From: Contact Centre (CRM) <contact@ribblevalley.gov.uk>
Sent: 31 October 2022 19:30
To: Planning
Subject: Planning Application Comments - 3/2022/0909 FS-Case-462241813

Planning Application Reference No.: 3/2022/0909

Address of Development: Pewter House Farm, Carr Lane, Balderstone BB27LN

Comments: I write to raise concerns regarding the application to convert 3 agricultural buildings into 5 residential properties at Pewter House Farm.

CLIENT DETAILS	DRAWING No	REVISION
MAIN STREET BINGLEY BRADFORD	RBV-PL 004	
DRAWING INFO	SCALE	DATE
Elevations as Proposed	1:100/200	05/09/22

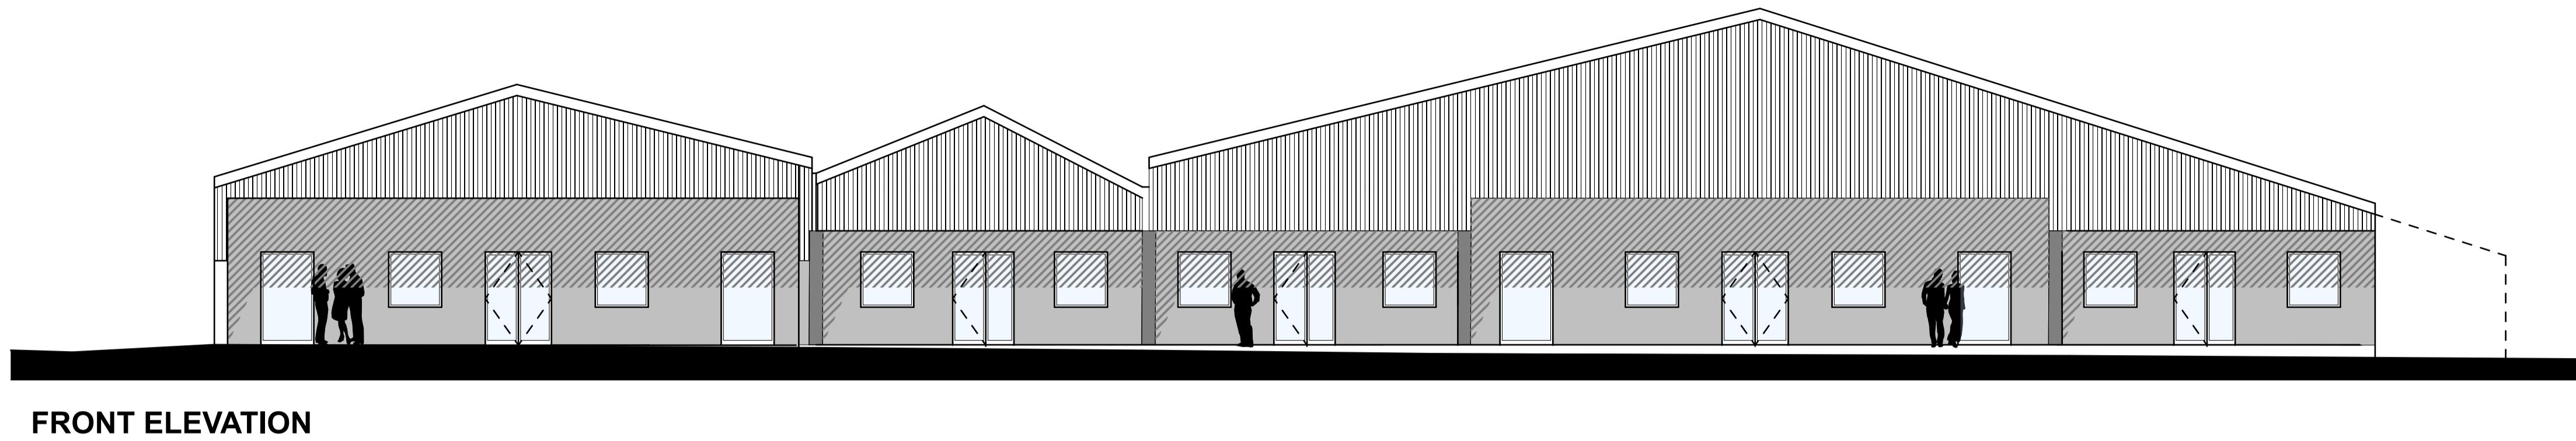
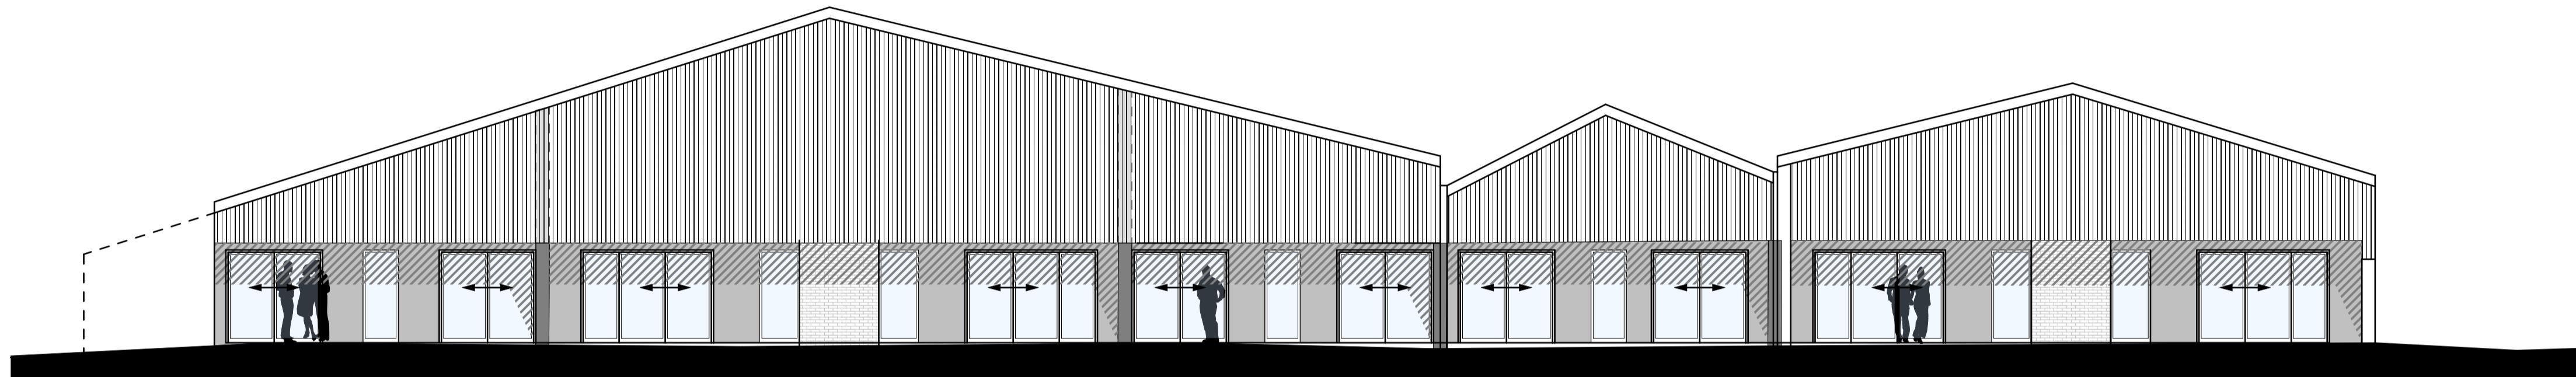
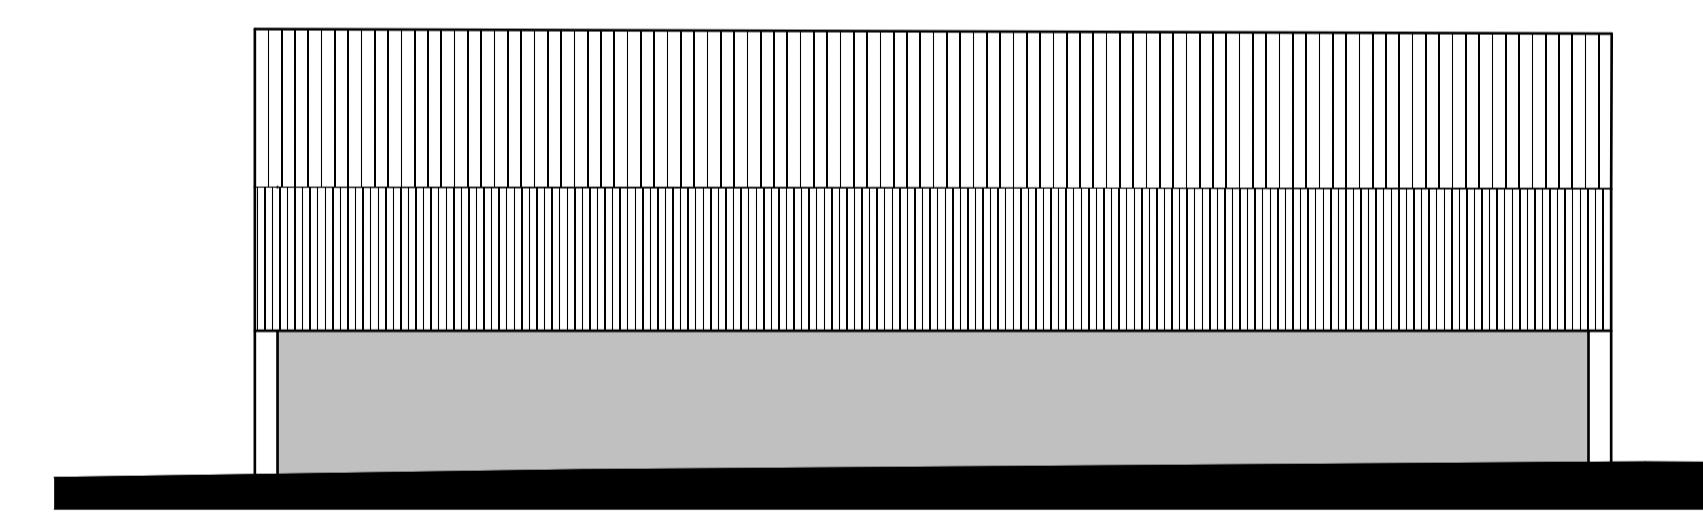
1. Appearance. Existing residential properties and the 3 holiday cottage lets in the immediate vicinity of Pewter House Farm proposal, are constructed of stone with blue slate roof. The proposed development would use a black metal roof, black stained timber wall cladding and black aluminum window frames. The resulting appearance is not in keeping with local residential properties and would look more like prison accommodation in an area of open countryside.
